Sweet Cherry Pie

Artform Home Plans
AFHP Design # 481.124.v2 KR
© 2012-2018 Art Form Architecture 603.431.9559
Sweet Cherry Pie
Lot 29 Stroudwater Preserve
Portland, ME
1
1/4"=1'-0" unless noted otherwise / Print @ 1:1
PDF created on: 7/19/2018, drawn by ACJ
Issued for: **Construction**

**Second Floor Plan**

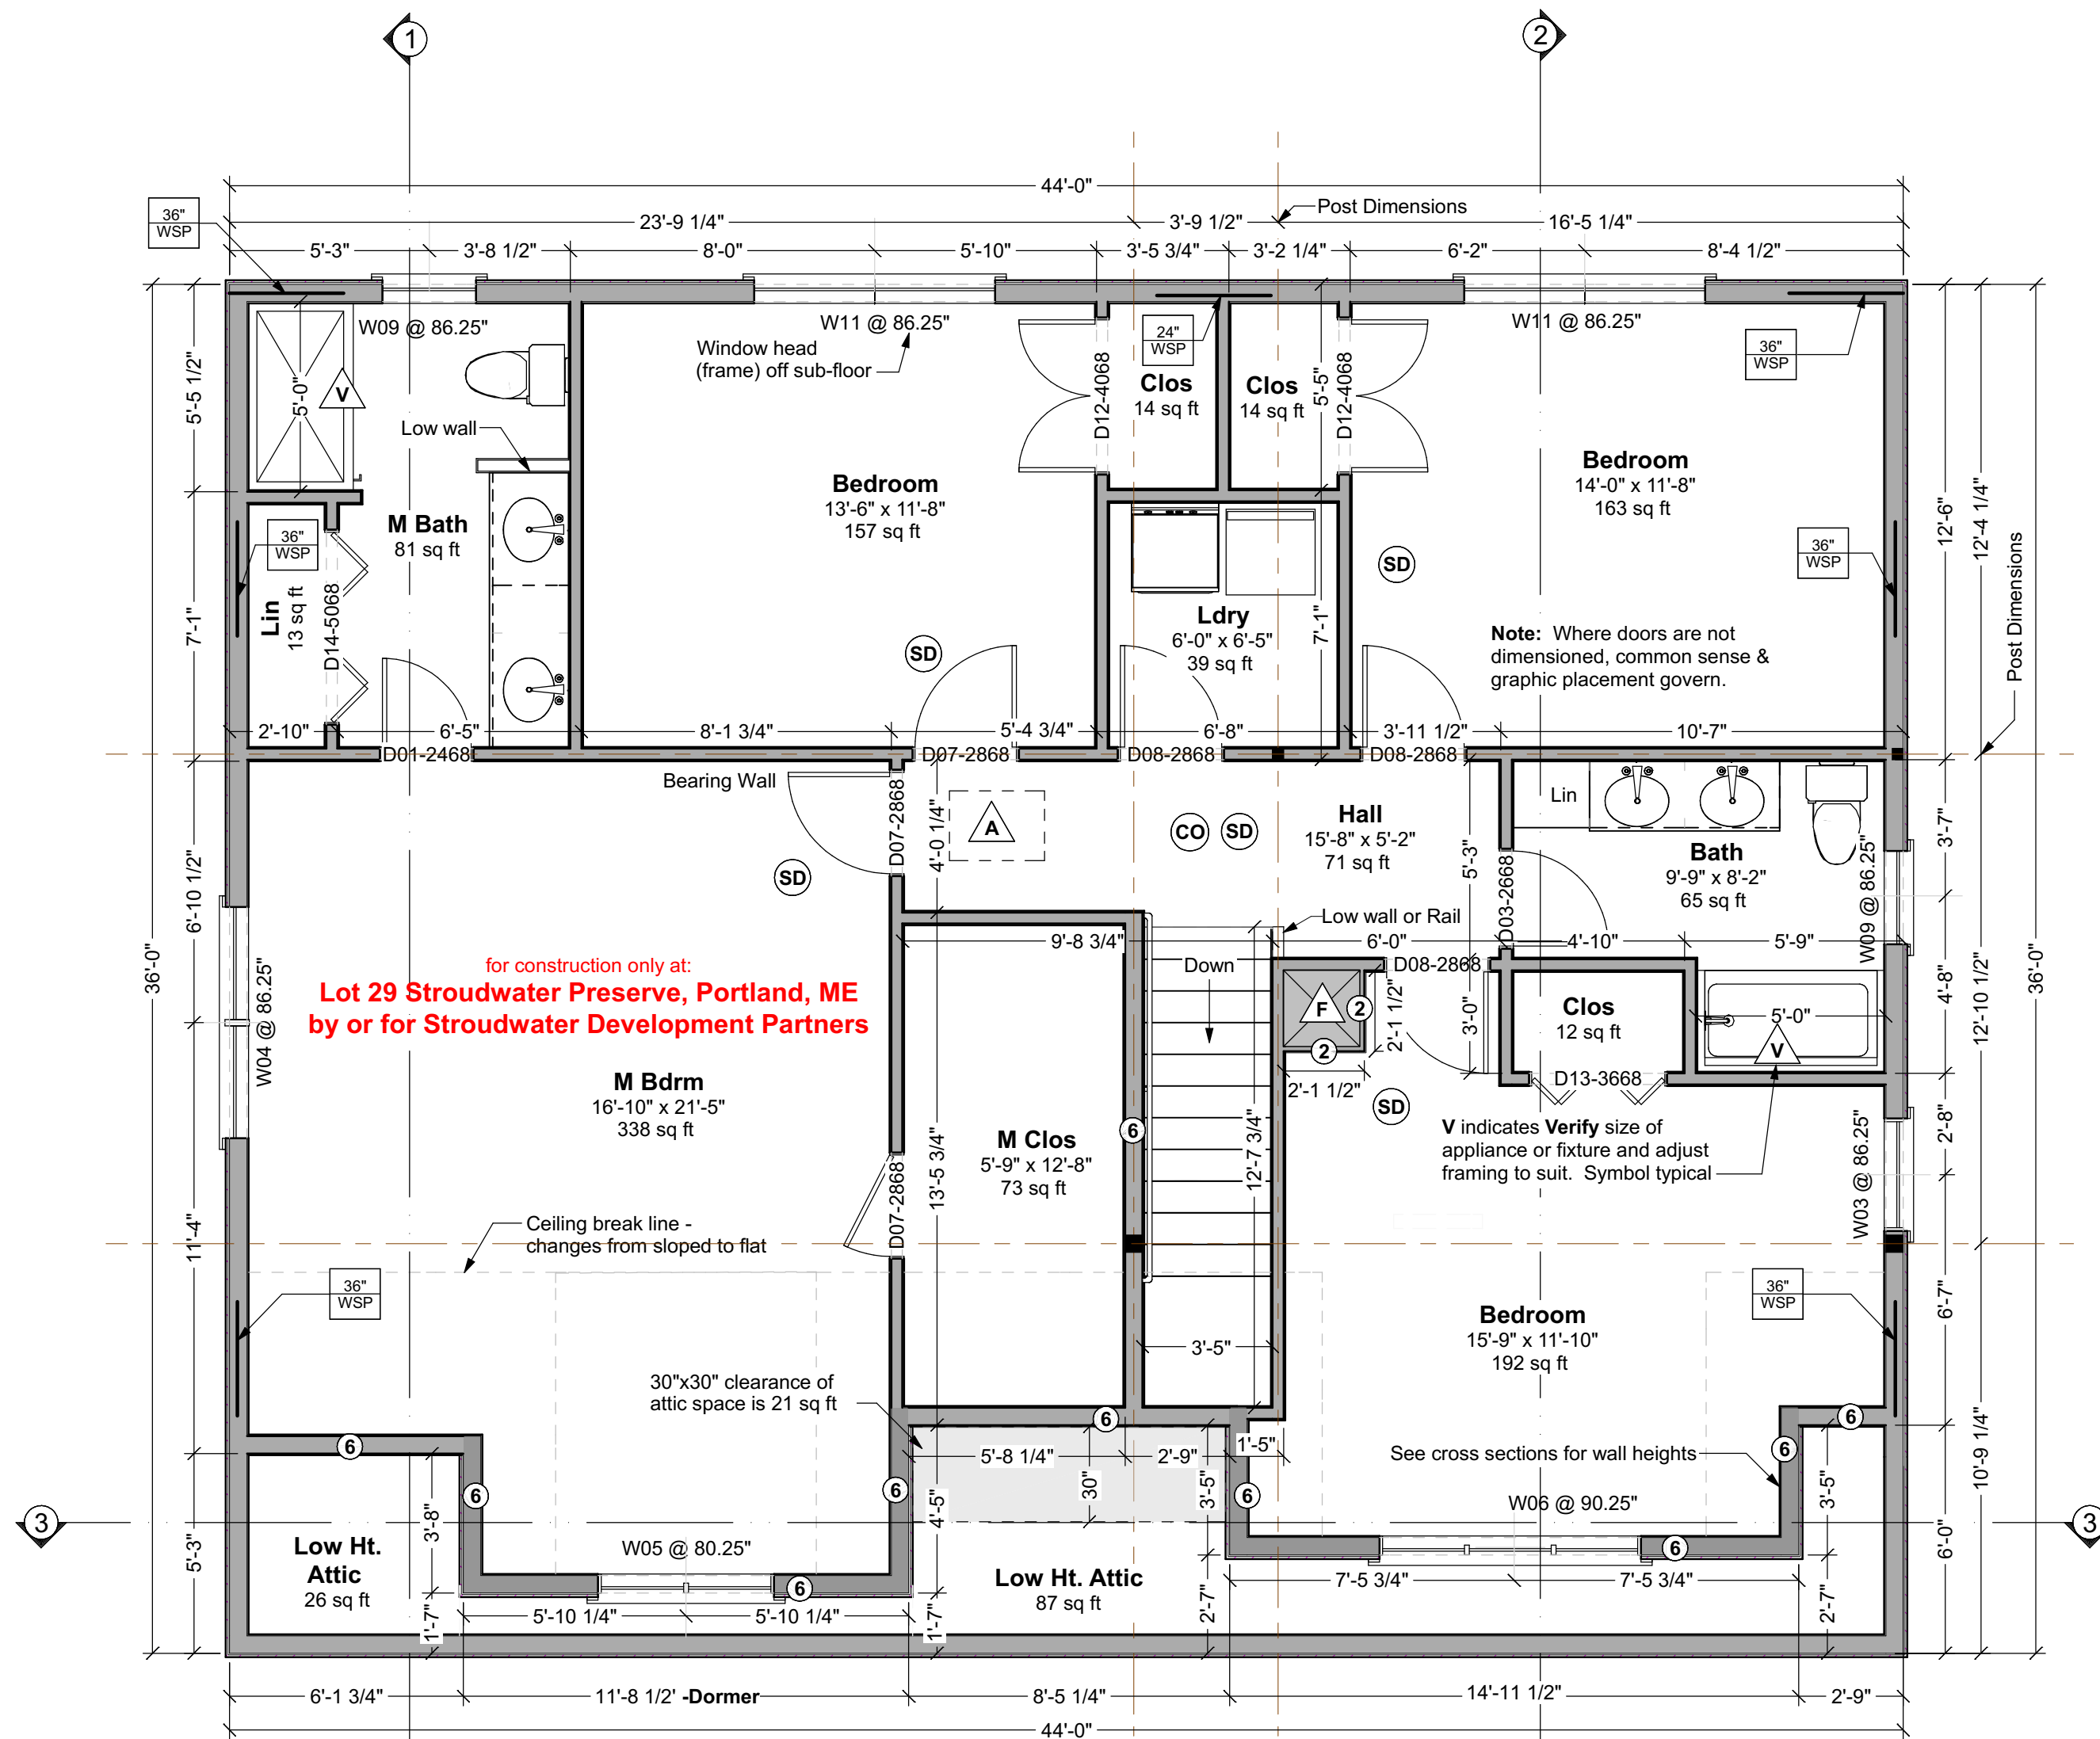
Riser height cannot exceed 7 3/4". Please show actual riser height for this stair.

### Foundation Plan

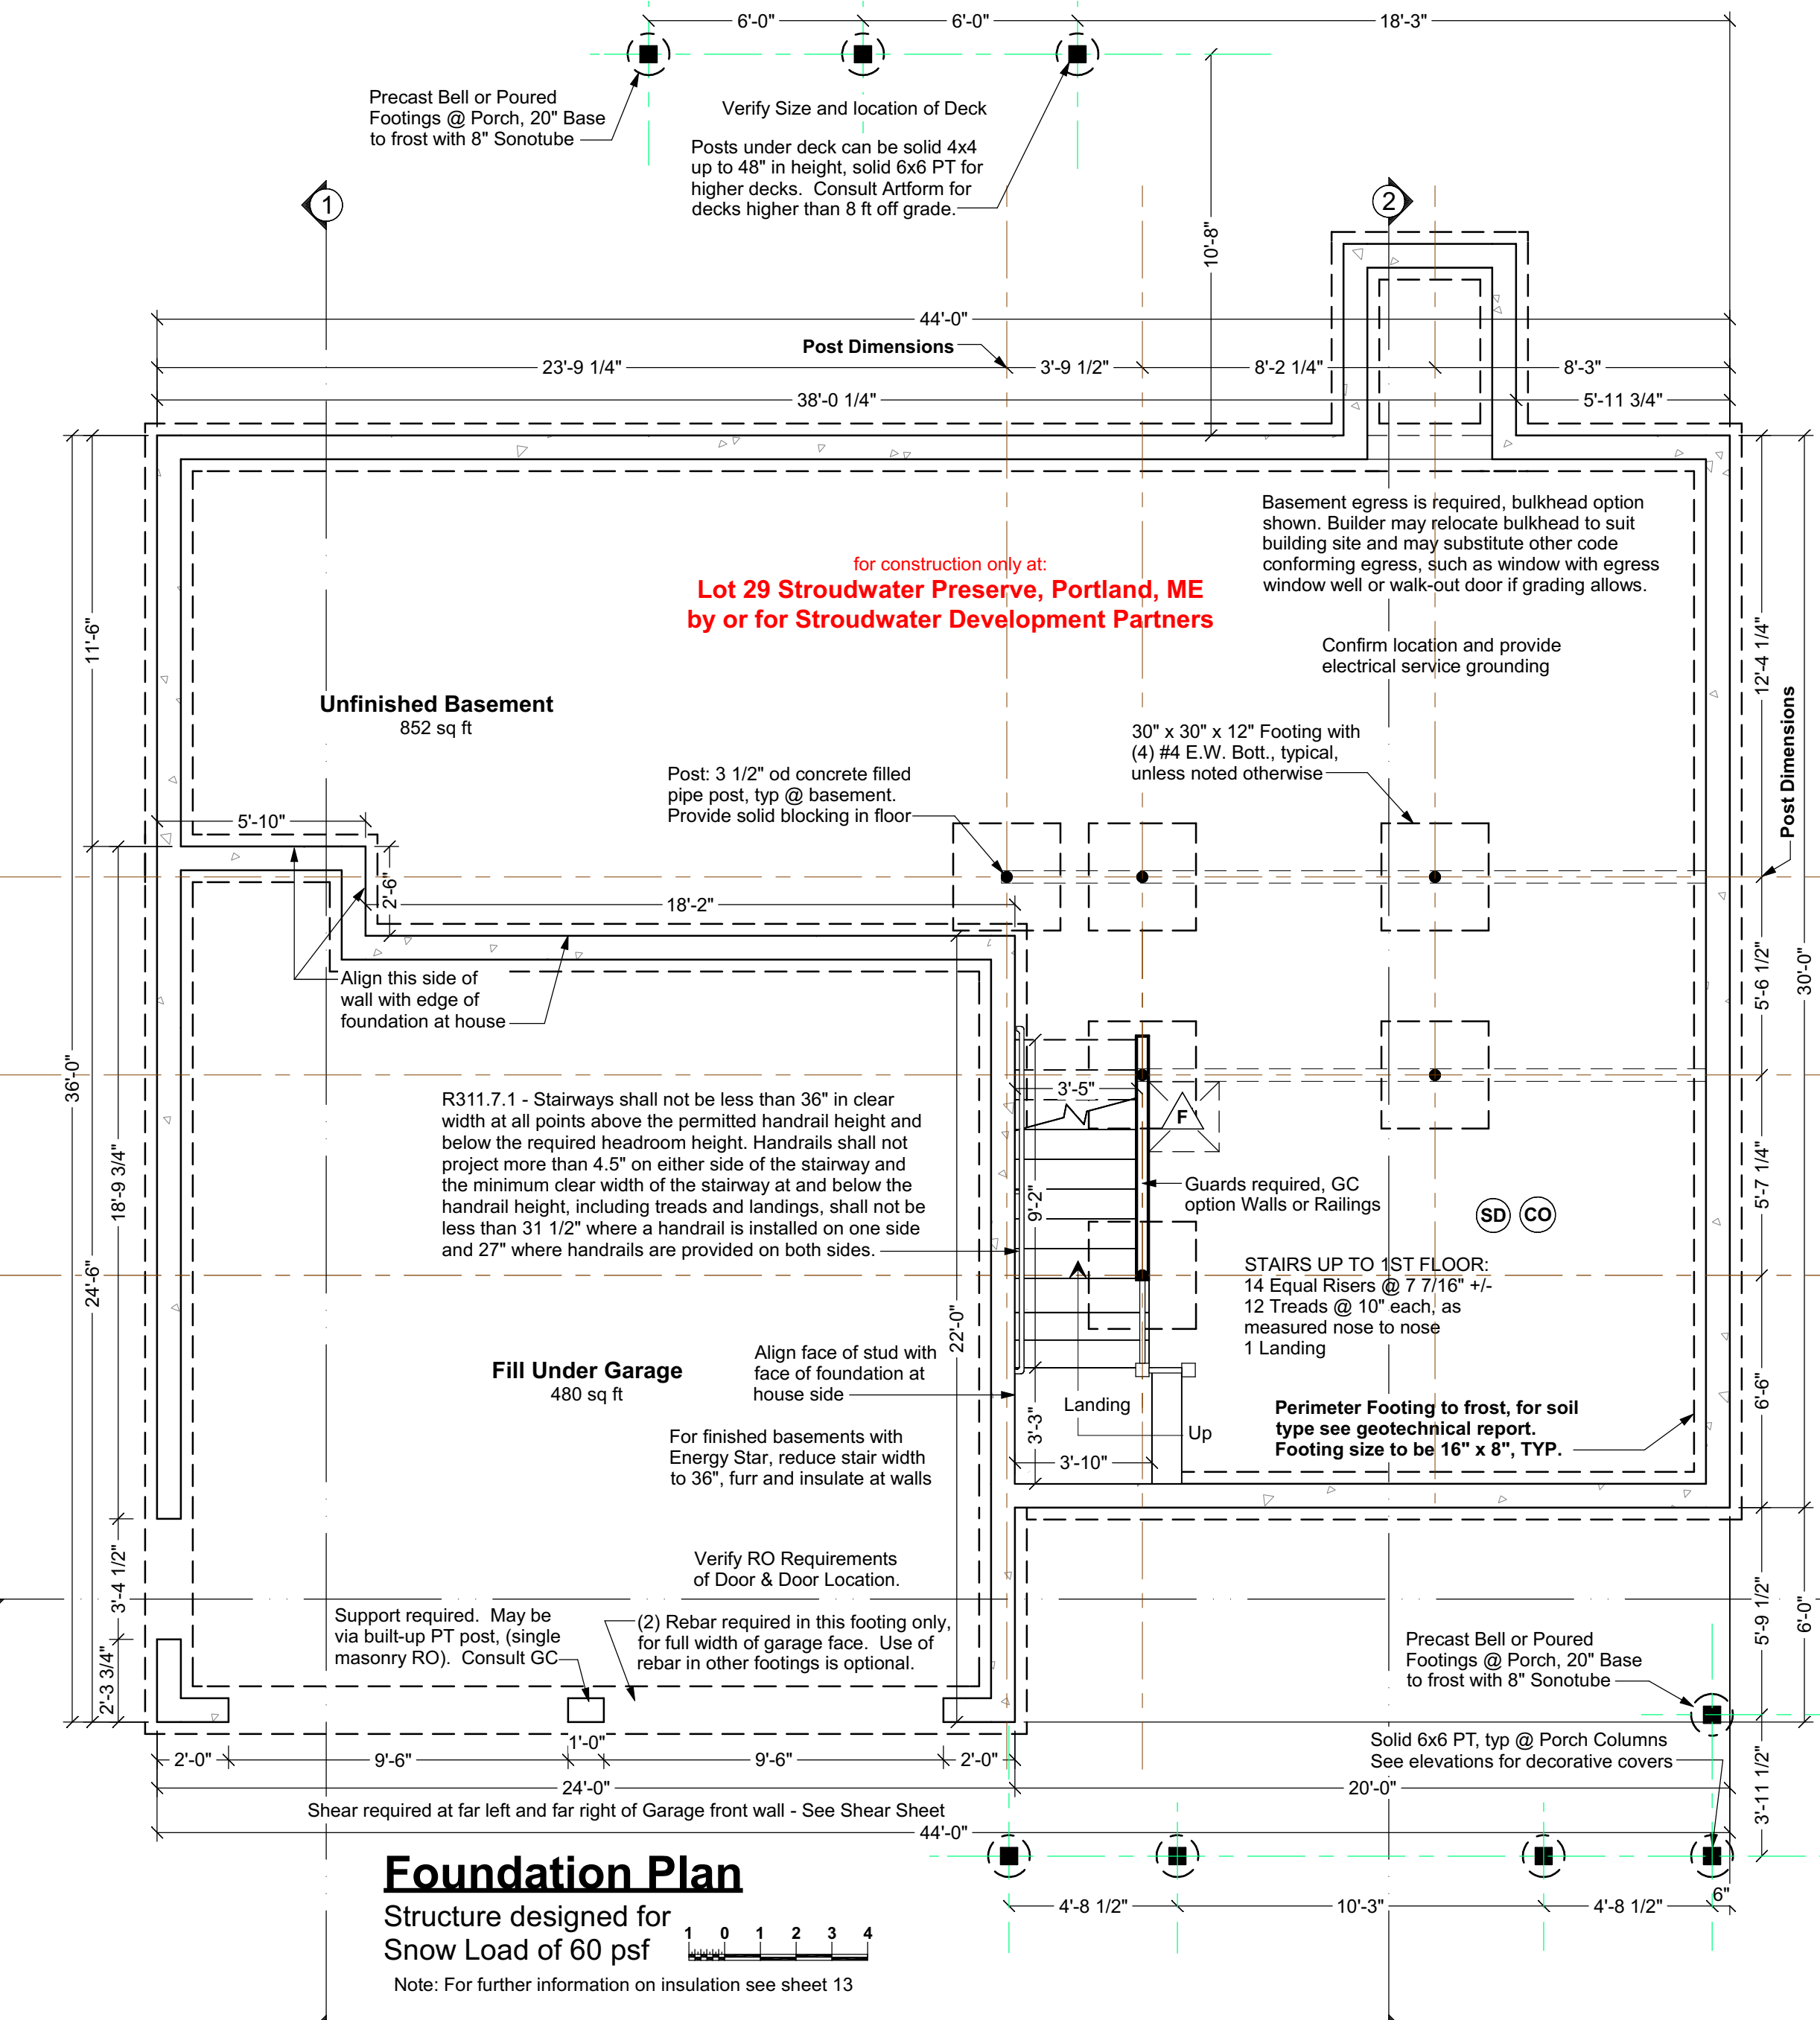
Not to Scale Show site specific frost depth on drawings (4'-0").
